From: Joanne OConnell
Sent: Monday, February 5, 2024 12:34 PM
To: 'Luke Clifton' <luke@247interiors.co.uk>
Subject: 3/24/0186/HH - Dial Cottage, Westmill SG9 9LB

The floor plan and elevations drawing provided would be ok, except that there is no scale bar on the drawing. We are also not able to accept the words printed on the drawing: "dimensions not to be scaled from this drawing", as the officer does need to be able to check the scale of the drawing. It is also entitled "block plan" which is incorrect, as the drawing shows a floor plan and elevations. Please make sure that amended plans submitted all have a plan number or reference.

BLOCK PLAN

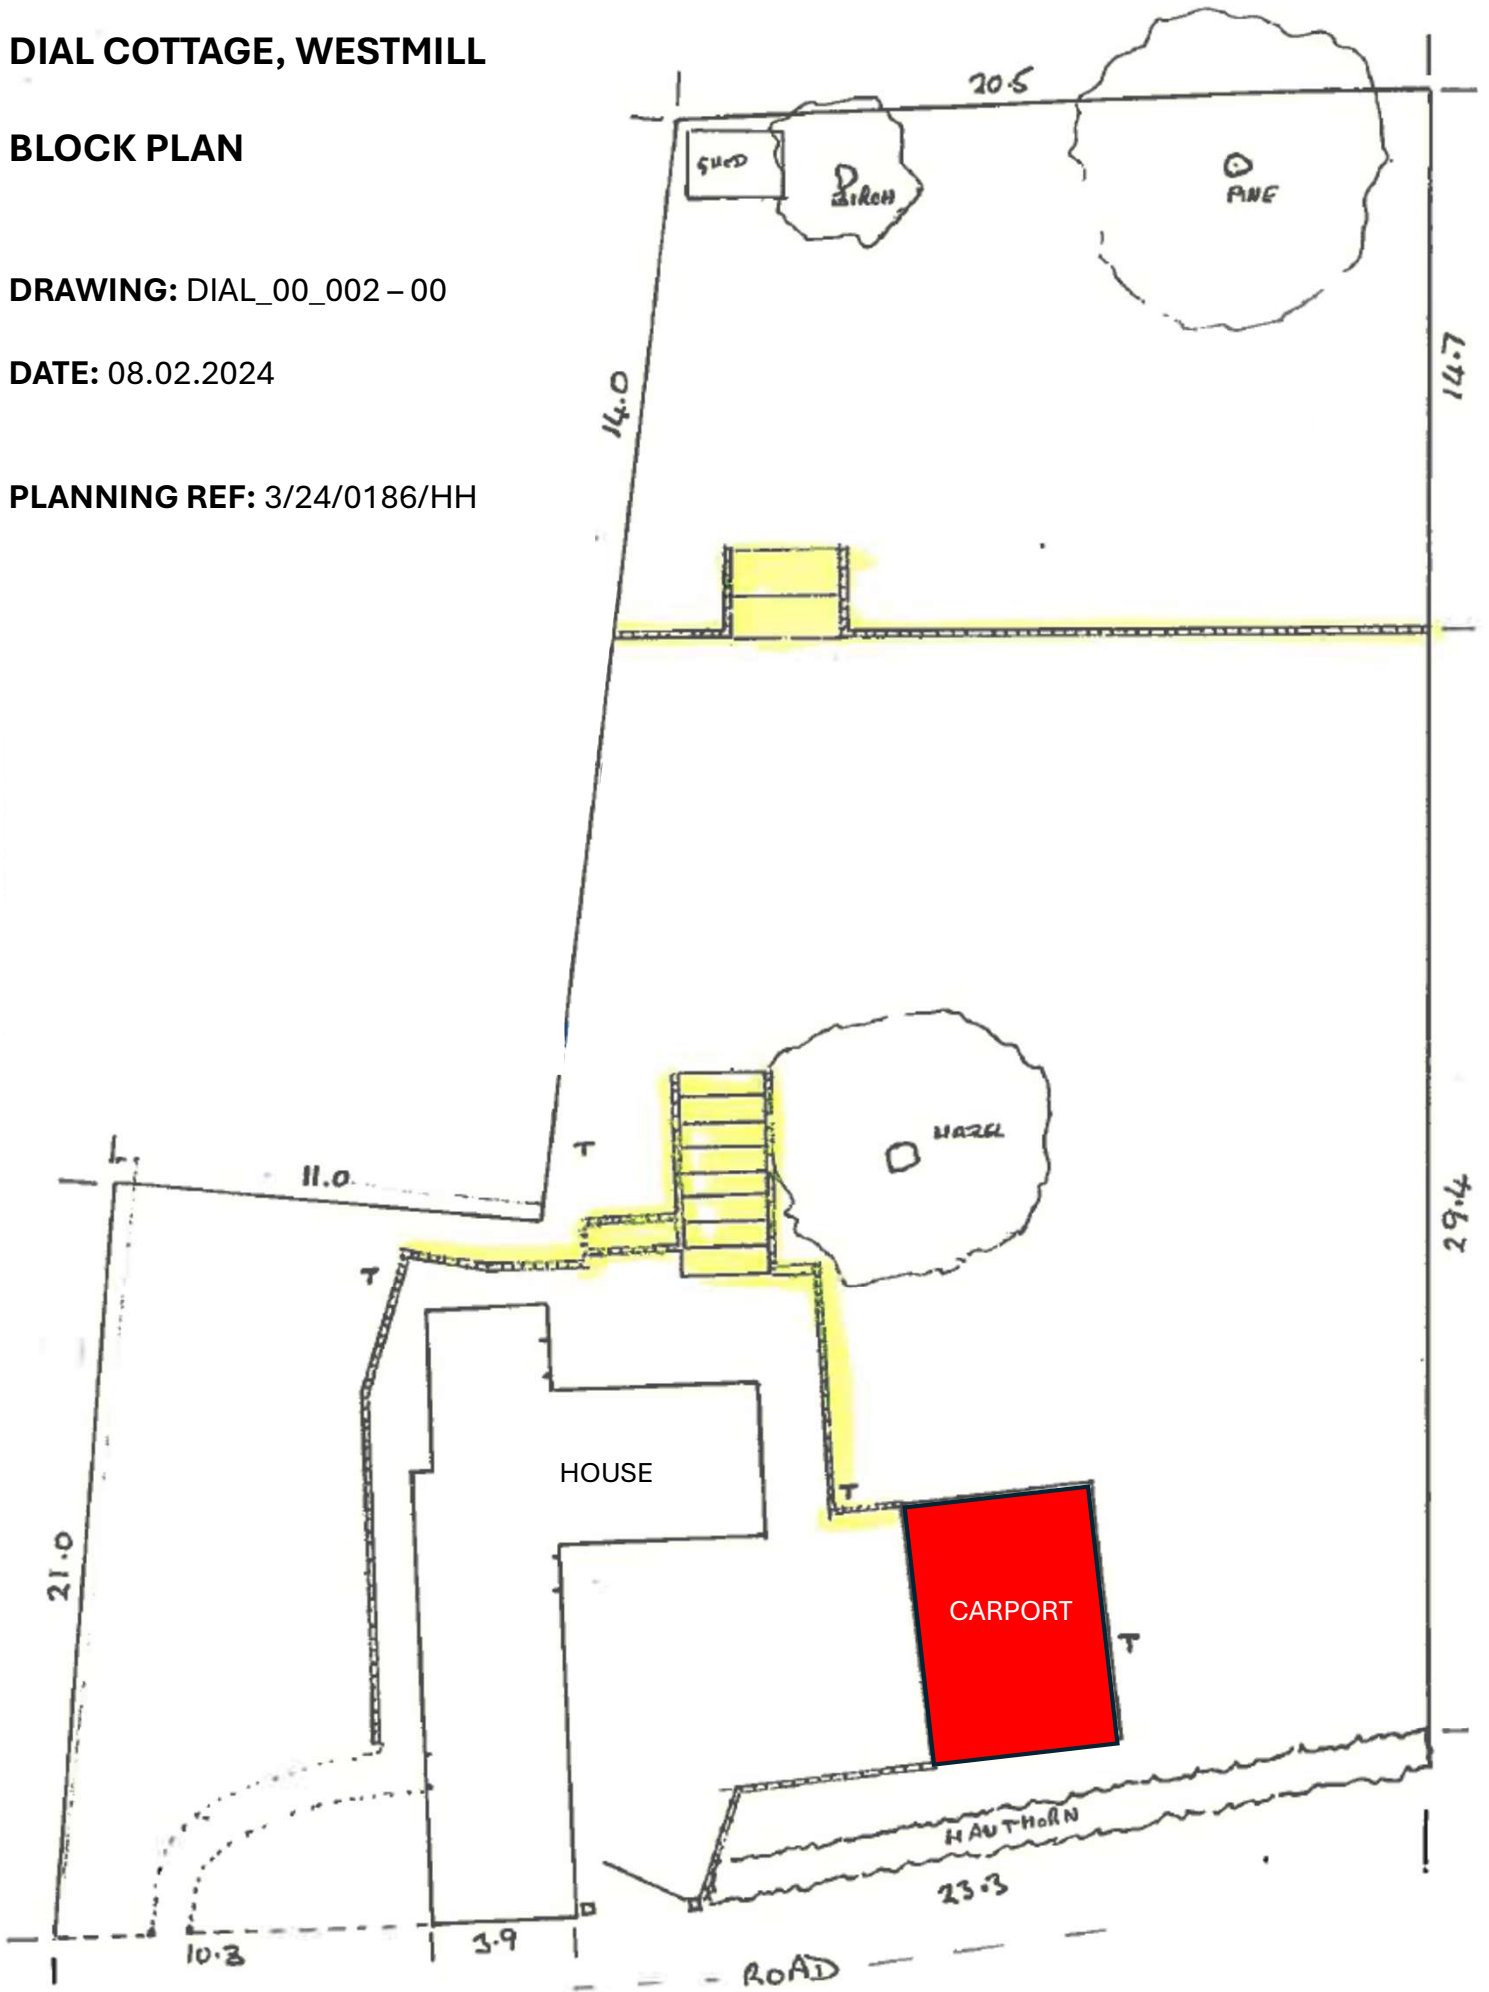
The format of the block plan provided would be ok, but the car port itself is not shown on the plan? Although this is shown on the location plan provided. I'm not sure why it wouldn't show on the block plan you've bought from the Planning Portal website, but we do need to have a current block plan which shows the car port to be converted to the Annexe, so that this shows the position of this, ideally in greater detail in relation to the main house.
